**Comments on any additional submissions received by Deadline 6**  
**ELMESTHORPE PARISH COUNCIL**  
**27<sup>th</sup> February 2024**

**2. 6.2.8.1D Hinckley NRFI ES Appendix 8.1 Transport Assessment (Part 15 of 20) Sustainable Transport Strategy and Plan Rev 8**

- 2.4. More specifically, referring to appendix 4 Cycle Routes Options Tables (**6.2.8.1D Hinckley NRFI ES Appendix 8.1 Transport Assessment (Part 15 of 20) Sustainable Transport Strategy and Plan (Appendices) Rev 7**):

Enhancement 1: Improved junction safety by introducing a Toucan Crossing.

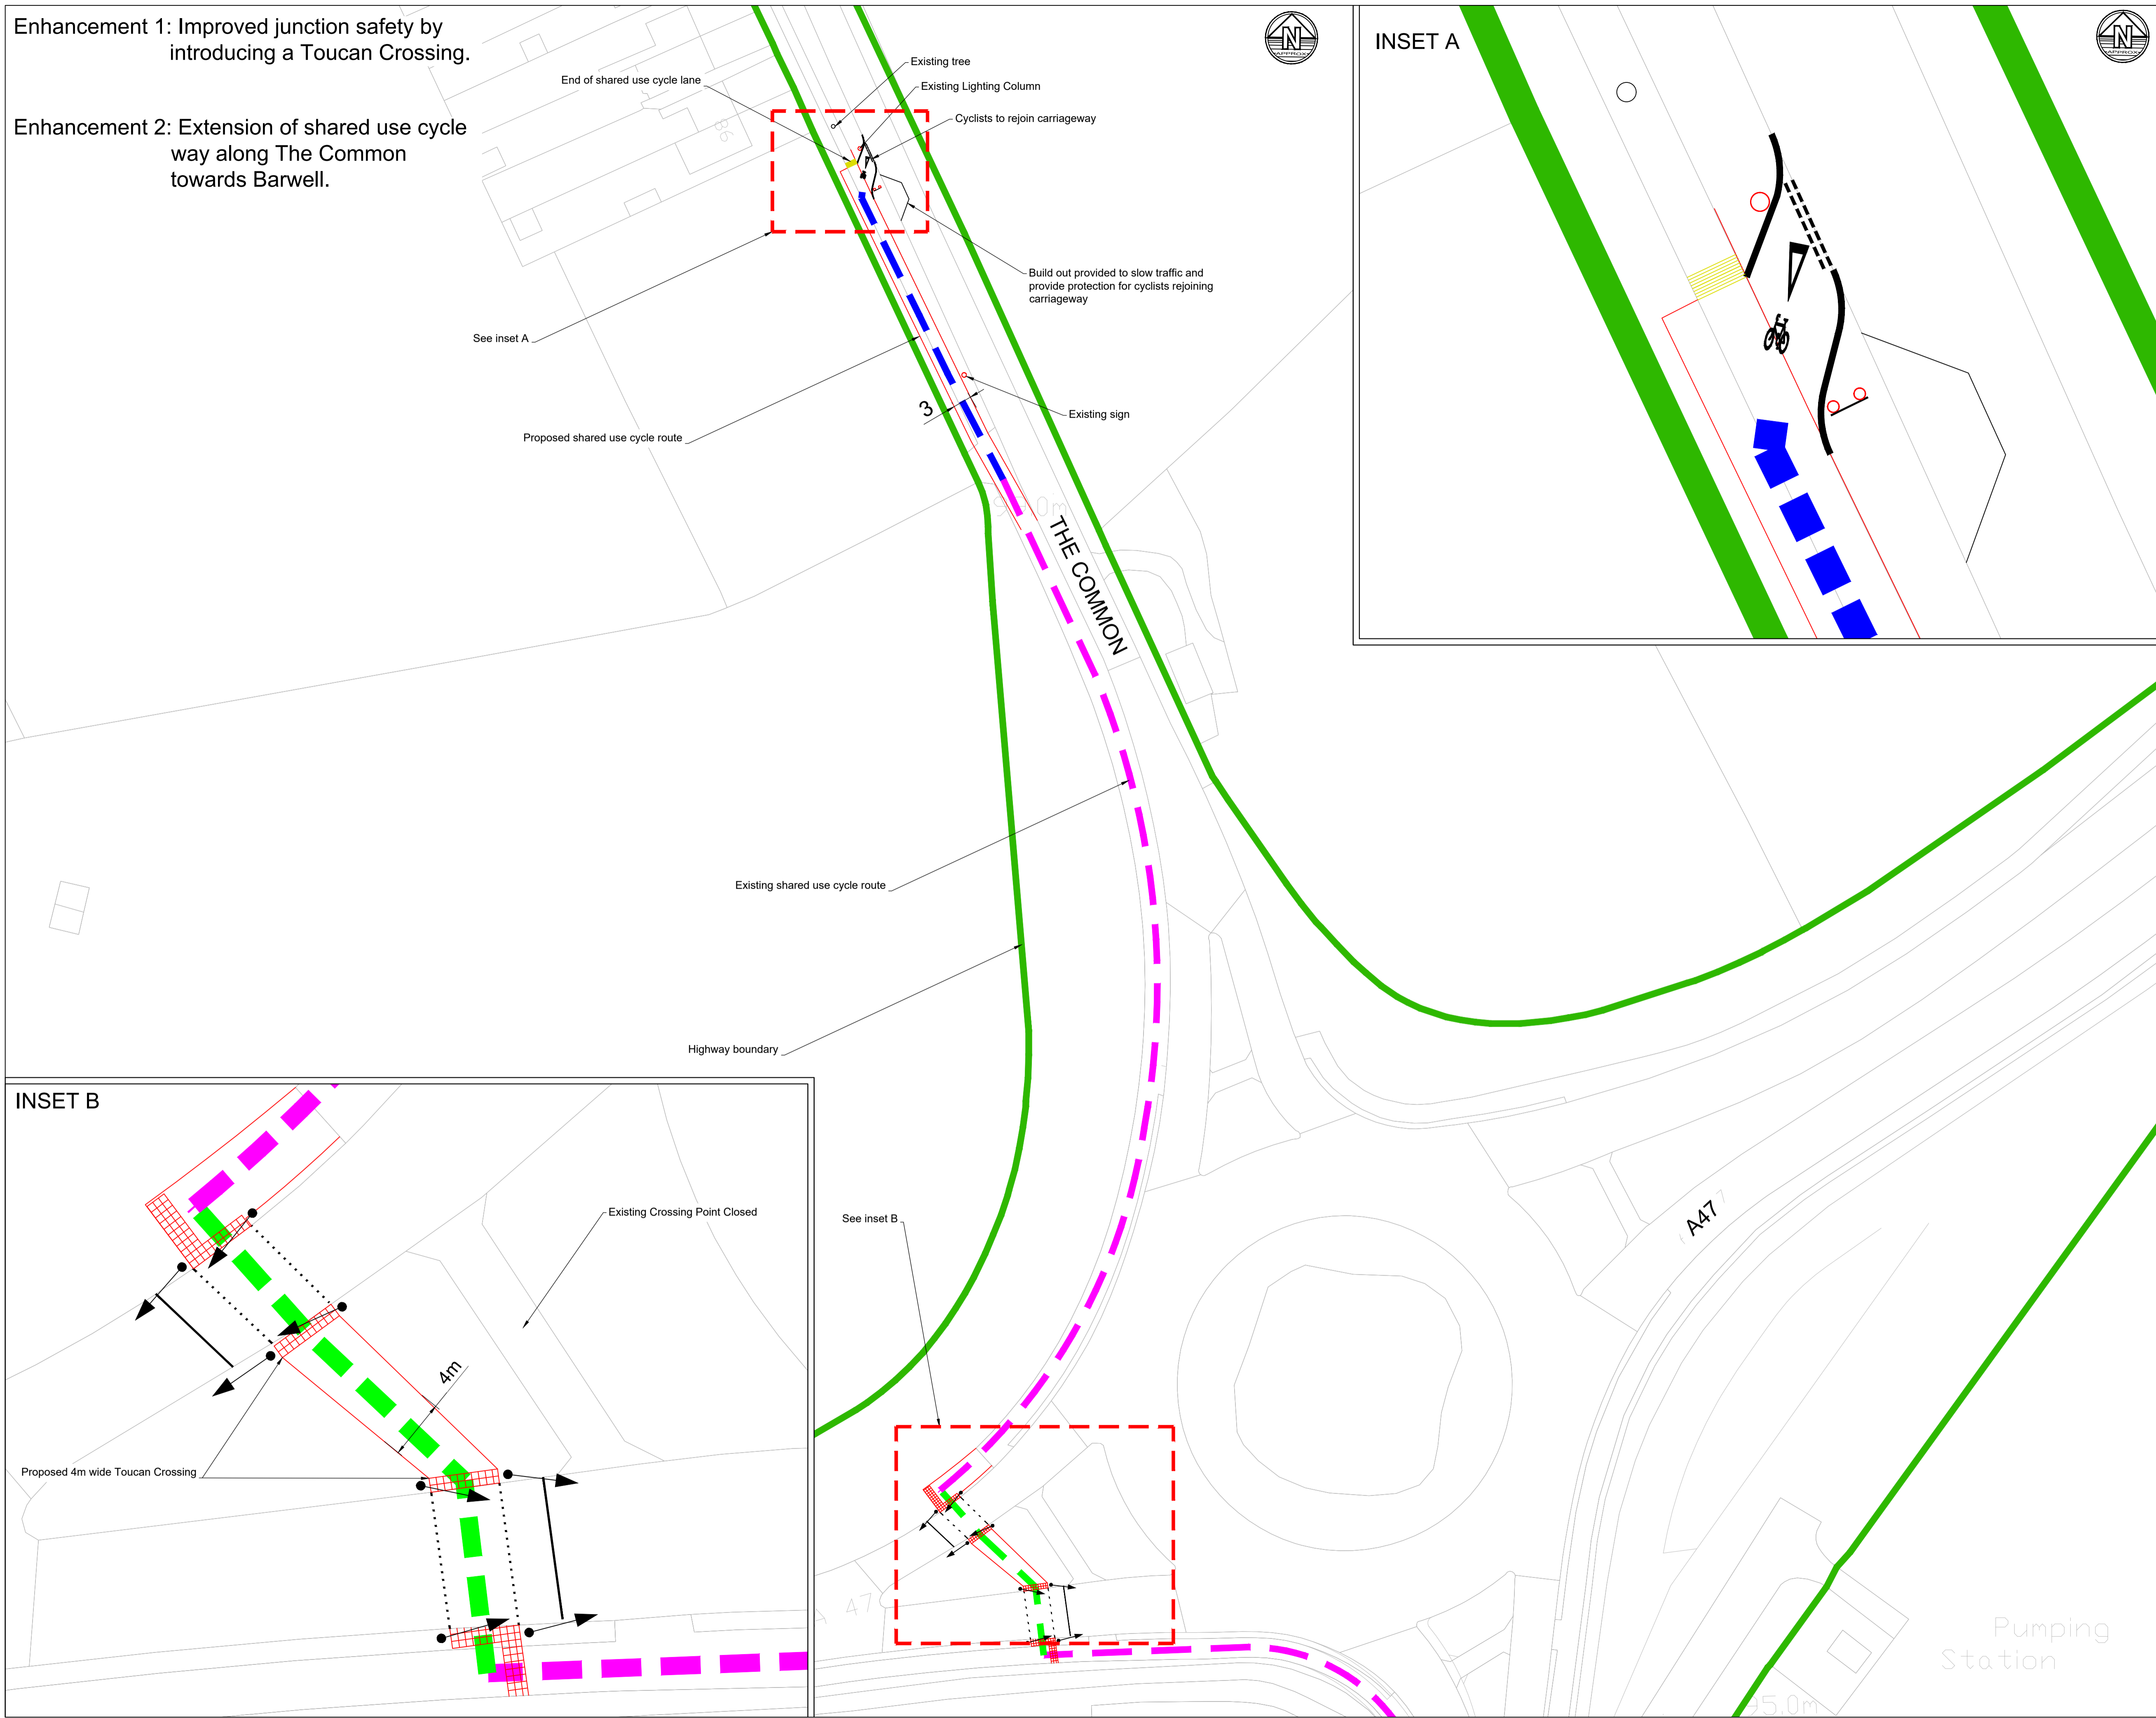
- 2.5. Enhancement Number 1: 'Toucan crossing over A47 [to enable] Safer access between Barwell and B4668.' Has modelling been done to demonstrate the effect that introducing a set of traffic signals on this approach/exit from this roundabout been undertaken? This is the main roundabout that traffic joining the A47 from the B4668/joining the B4668 from the A47 as a result of the new A47 Link Road will be utilising. The effect of introducing traffic signals could be significant when factoring in the large increase in additional traffic.

Enhancement 2: Extension of shared use cycle way along The Common towards Barwell.

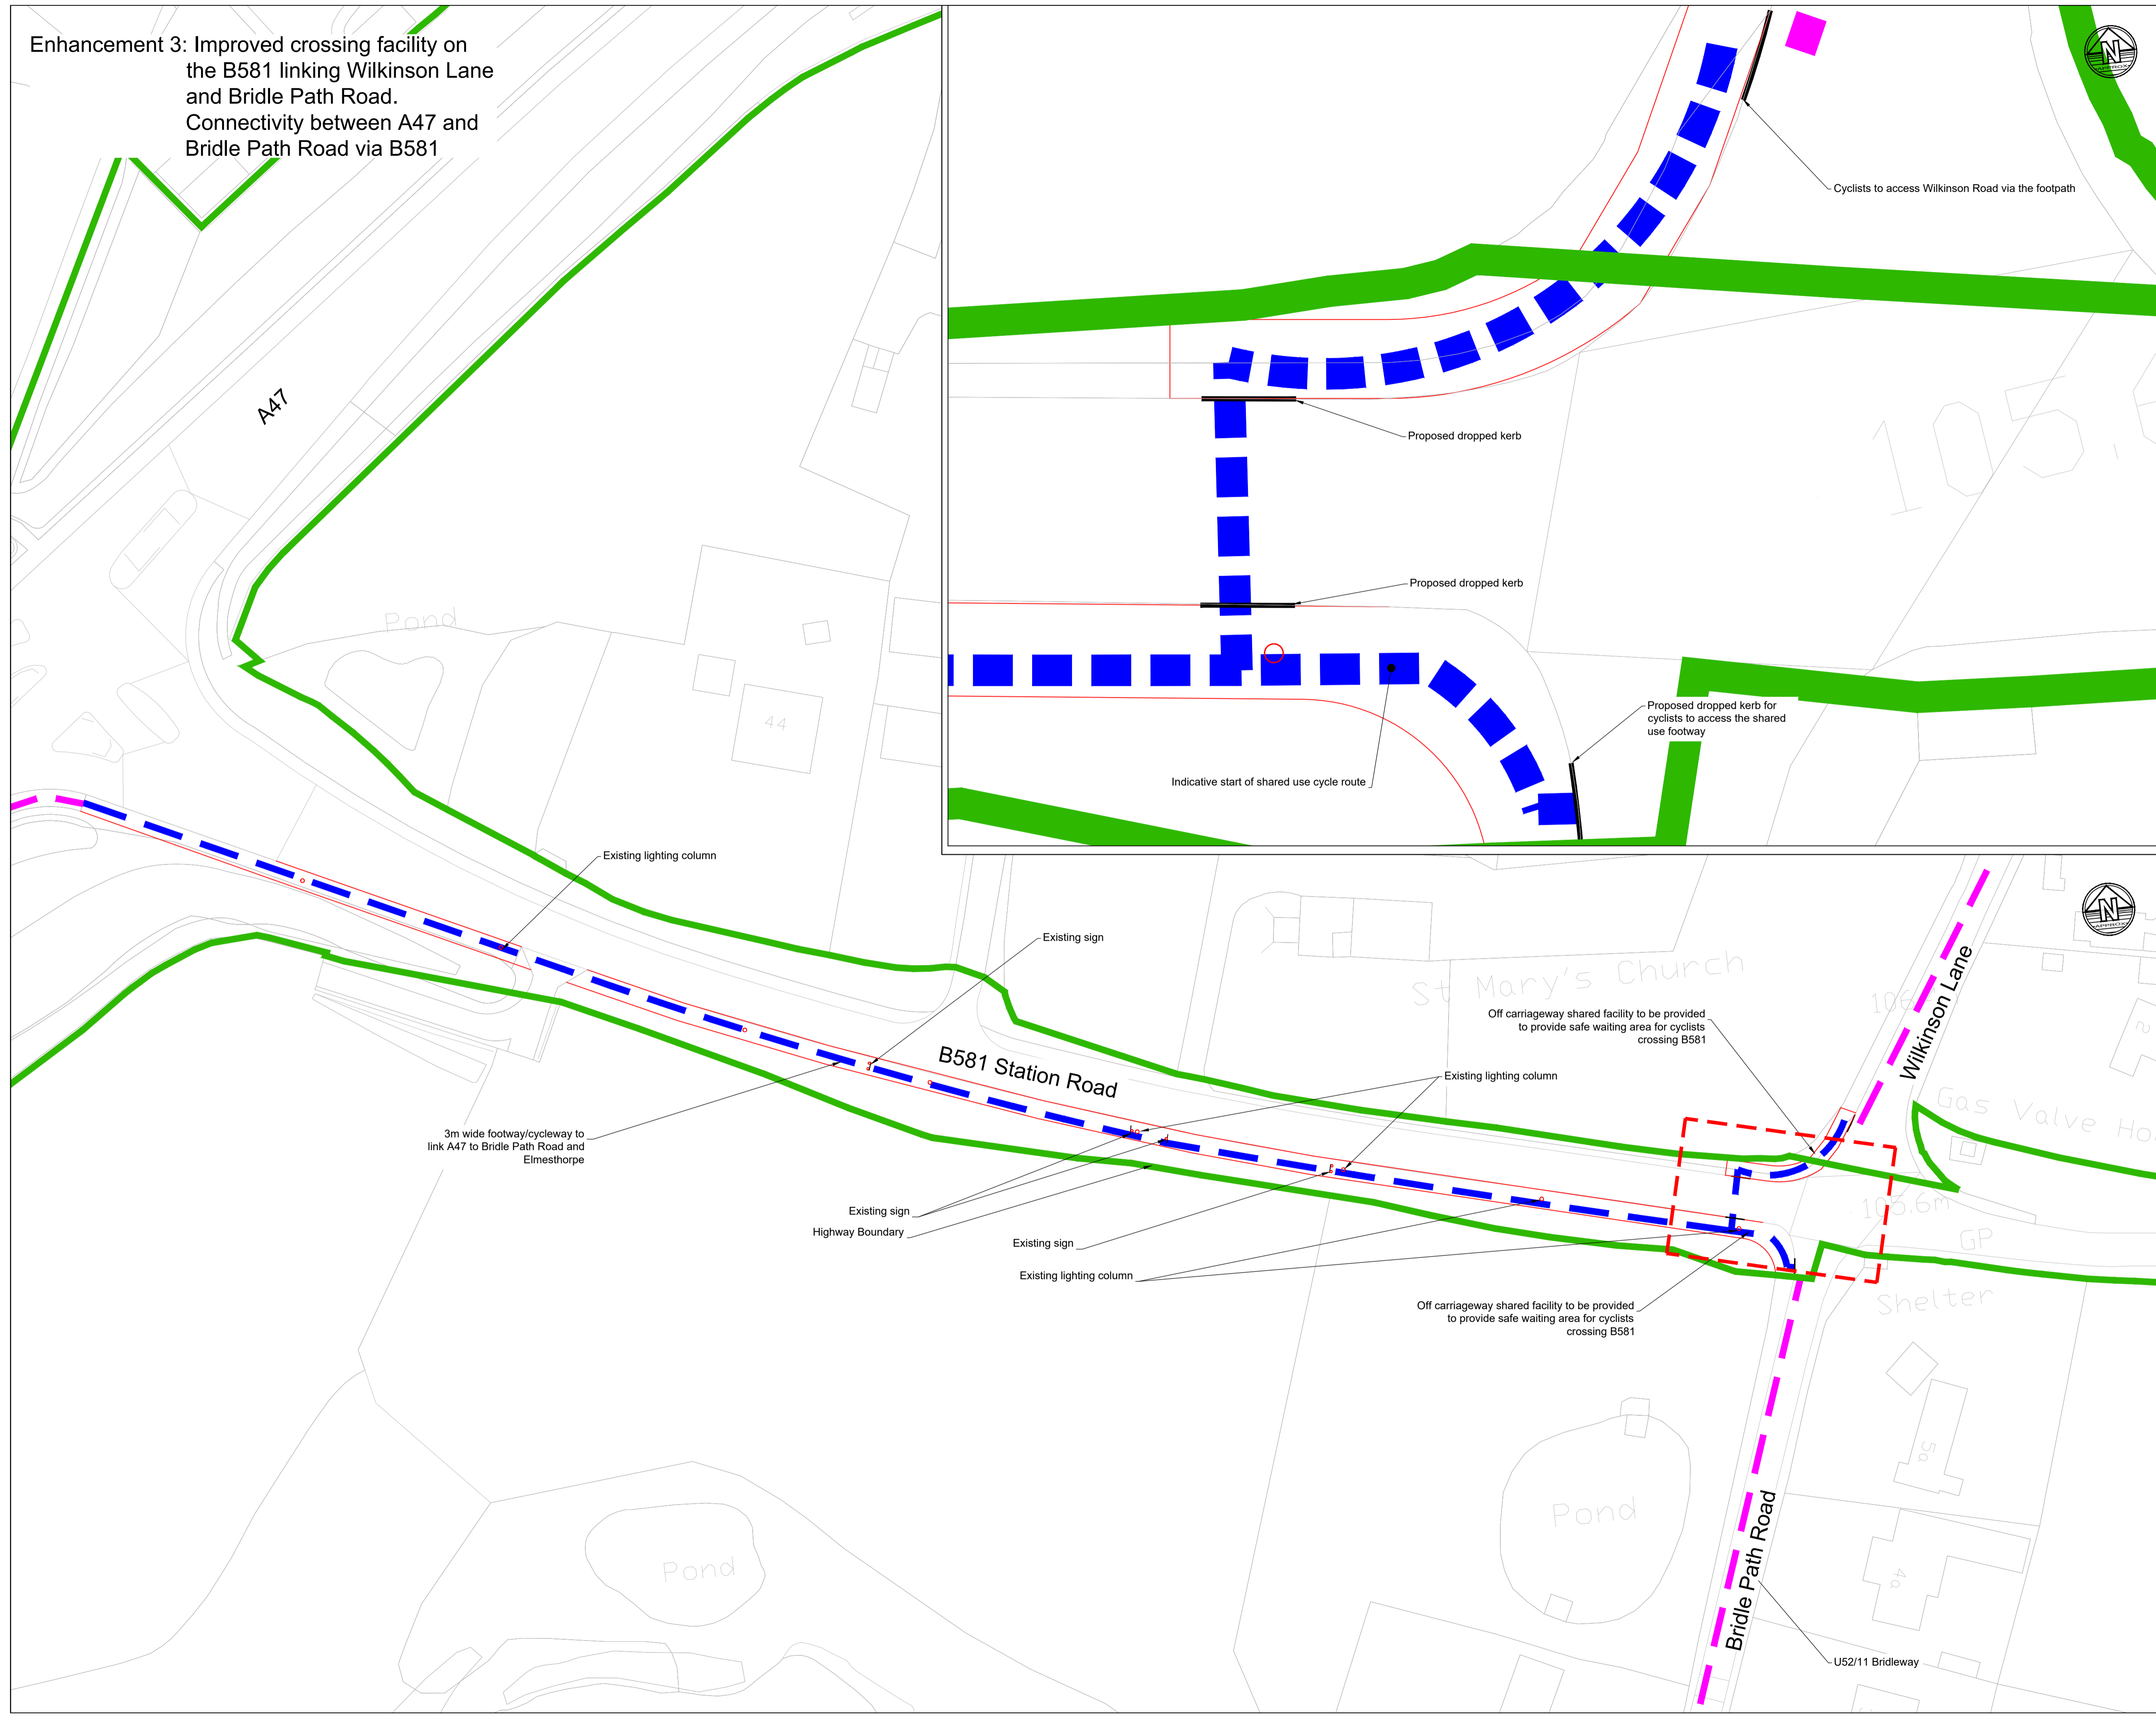
- 2.6. Enhancement Number 2: ...'Introduction of gateway feature to provide protection to cyclists rejoining carriageway.' There would absolutely need to be modelling done to investigate the effects of introducing a gateway feature here. Especially when considering the additional introduction of traffic signals as part of Enhancement 1. As previously discussed, traffic on and around this roundabout stands to increase with the introduction of the A47 Link Road, as a crucial part of the HNRFI route. Elements that could create potential delays and traffic queues on this roundabout need thorough assessment and modelling. There should also be attention drawn to the fact that there are notable amounts

of parked cars on the carriageway of The Common and introducing a gateway feature could prove problematic for traffic travelling in both northerly and southerly directions.
